AL/124/18/L

The application is for a two storey side extension which has previously been approved. I note that the applicant identifies the fact that Listed Building Consent has not previously been requested from the Local Planning Authority.

Drawing Title:
Proposed Floor Plans

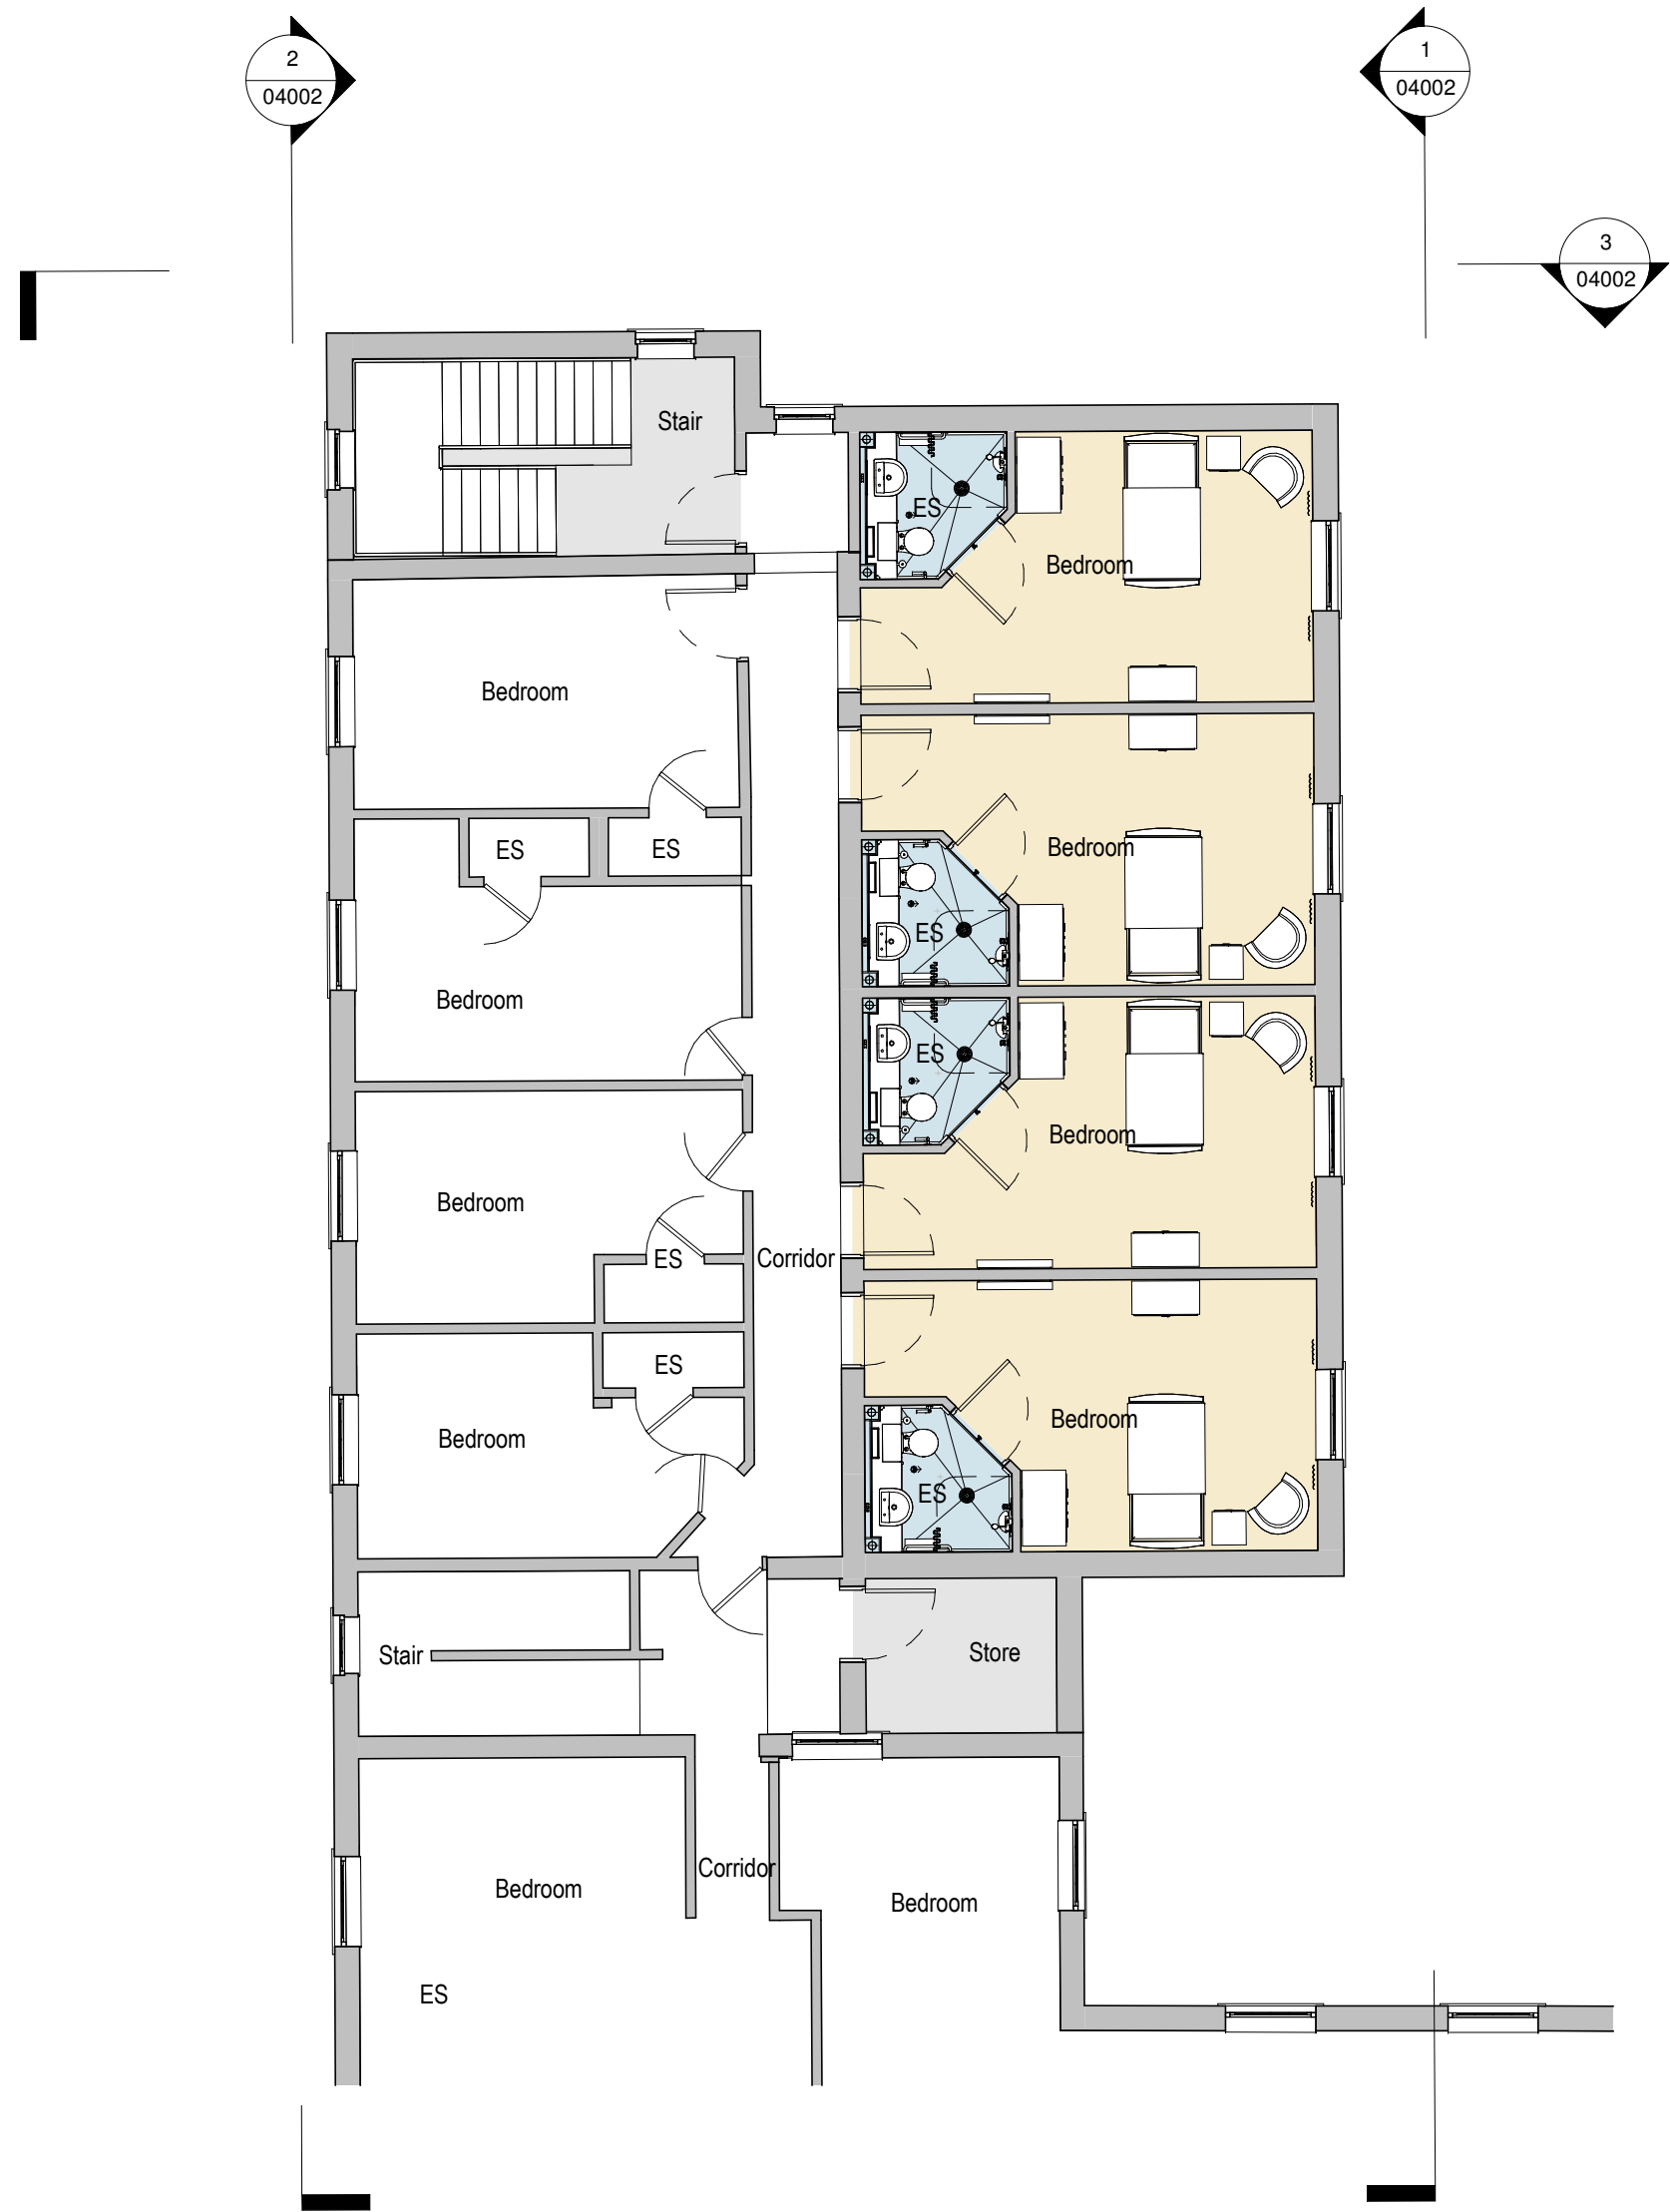
The application is a two storey extension which would be visible from the front elevation. The extension would form an extension to a number of previous extensions to the building. As such it is not directly attached to the original listed structure.

I note that the intention is to replicate the existing exterior in terms of appearance and materials. Such an approach is acceptable. However the location of the extension would be problematic and potentially cause harm. Such harm would have to be weighed against the public benefit of the creation of additional accommodation that would meet the needs of local residents to a modern standard. Such a benefit could be considered acceptable related to the harm caused.

If minded to approve, details of the materials and joinery should be provided to the council for review.
